# **Applicant's Comments on Responses submitted for Deadline 5 & Action Points for Issue Specific hearings**

**Application by ESSO Petroleum Company Ltd  
for an Order Granting Development  
Consent for the Southampton to London  
Pipeline Project**

**Application Reference EN070005**

## **Applicant's Comments on Responses submitted for Deadline 5, excluding comments on the HRA**

Illustration 3.3: Outline proposal for Cove Brook Dam crossing

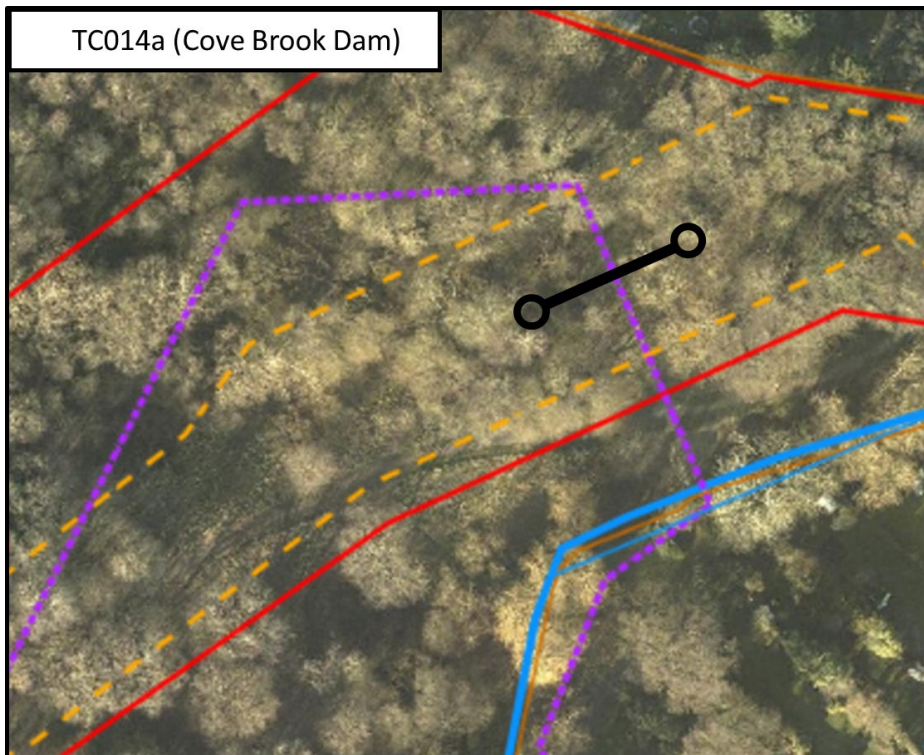
- 1.1.14 **Discharge** – RBC acknowledges that we misunderstood this section.
- 1.1.15 **Construction Program** – RBC did not state that work should be undertaken within the Flood Storage Area during the winter what was actually said was work should not be undertaken within the bird breeding season. This allows the autumn period to undertake this work.
